THE TRAILS AT ASPEN RIDGE FILING NO.2

A SUBDIVISION OF A PORTION OF TRACT Q AND TRACT R OF THE TRAILS AT ASPEN RIDGE FILING NO.1
 LOCATED IN THE WEST 1/2 OF SECTION 9,
 TOWNSHIP 15 SOUTH, RANGE 65 WEST OF THE 6TH P.M.
 EL PASO COUNTY, COLORADO
 SHEET 2 OF 3

Plat_v1.pdf Markup Summary

**THE TRAILS AT ASPEN RIDGE FILING NO.2**  
 A SUBDIVISION OF A PORTION TRACT Q AND TRACT R OF THE TRAILS AT ASPEN RIDGE FILING NO.1  
 LOCATED IN THE WEST 1/2 OF SECTION 9,  
 TOWNSHIP 15 SOUTH, RANGE 65 WEST OF THE 6TH P.M.  
 EL PASO COUNTY, COLORADO  
 SHEET 2 OF 4

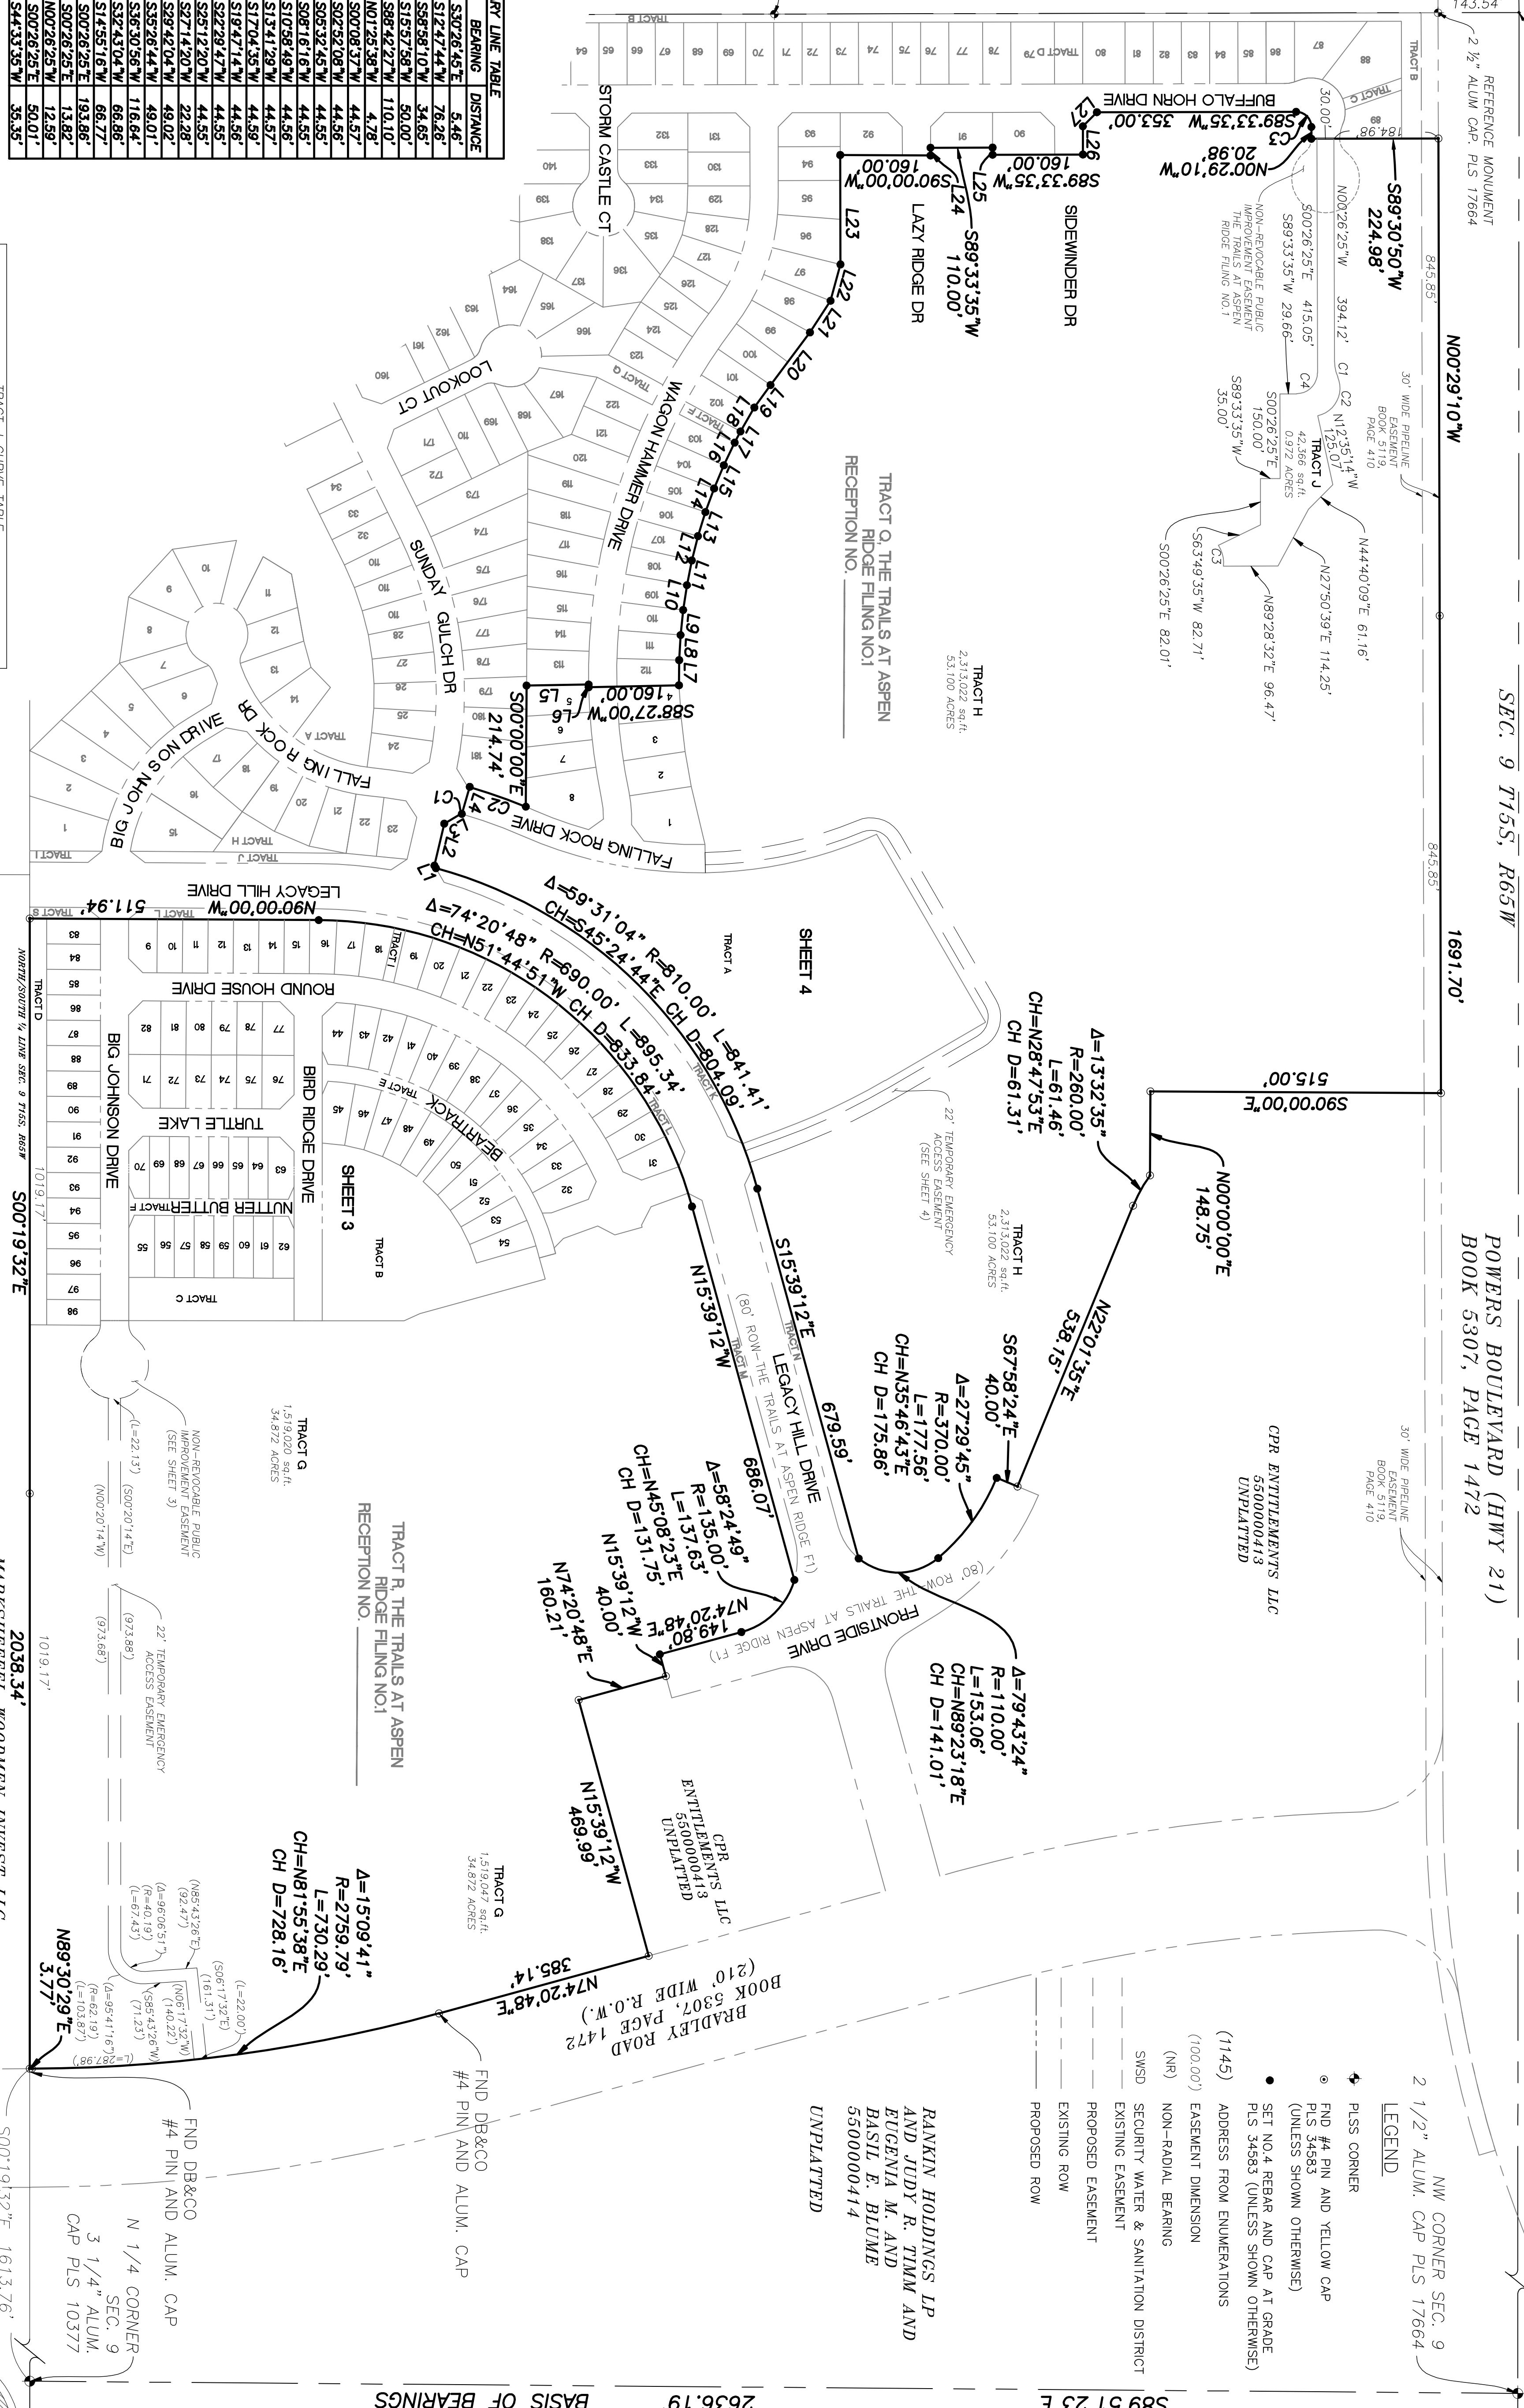
Revise all private roads from ROW to Tract.

Add the following plat note:

- The private roads as shown on this plat will not be maintained by El Paso County unit and unless the streets are constructed in conformance with El Paso County standards in effect at the date of the request for dedication and maintenance.

Vacate the temporary emergency access easement within Filing 2.

Remove: Filing 1 plat does not indicate a non-reversible public improvement easement for temp turnaround at this location.

**THE TRAILS AT ASPEN RIDGE FILING NO.2**  
 A SUBDIVISION OF A PORTION TRACT Q AND TRACT R OF THE TRAILS AT ASPEN RIDGE FILING NO.1  
 LOCATED IN THE WEST 1/2 OF SECTION 9,  
 TOWNSHIP 15 SOUTH, RANGE 65 WEST OF THE 6TH P.M.  
 EL PASO COUNTY, COLORADO  
 SHEET 3 OF 4

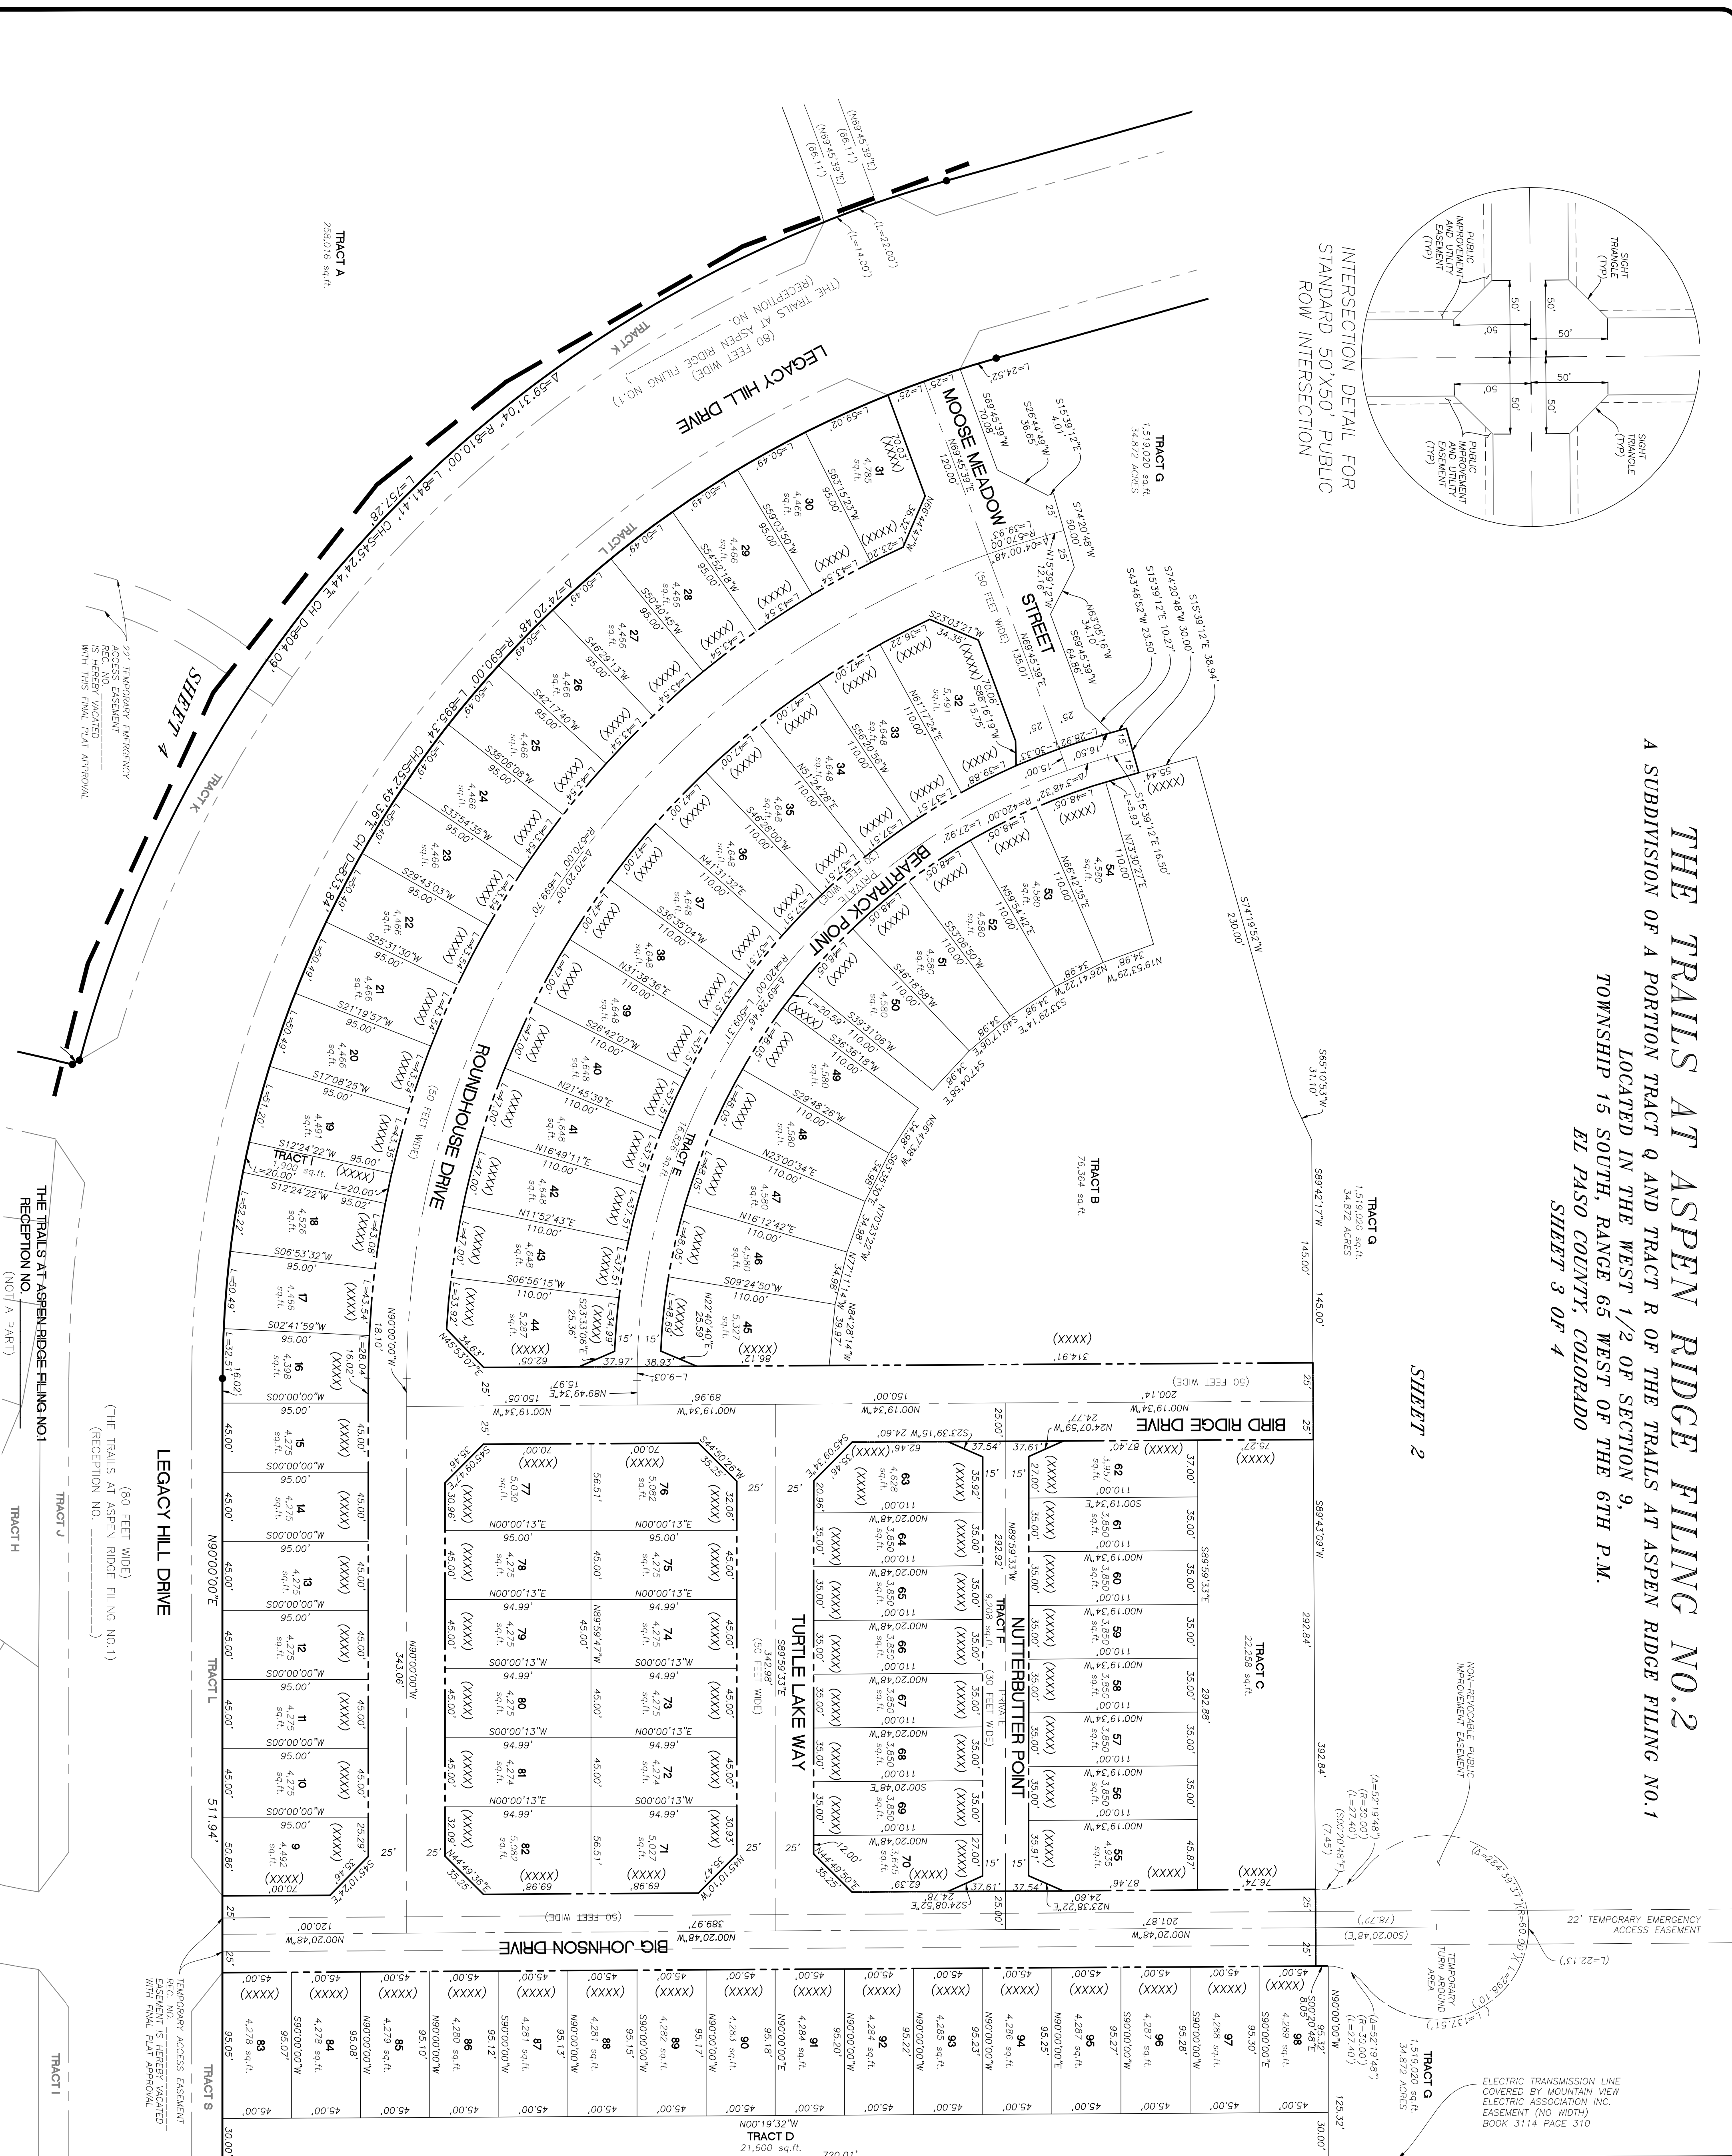
TR4 Vacate temporary easement with final plat approval. Based on the construction plans, this is no longer an appropriate emergency access.
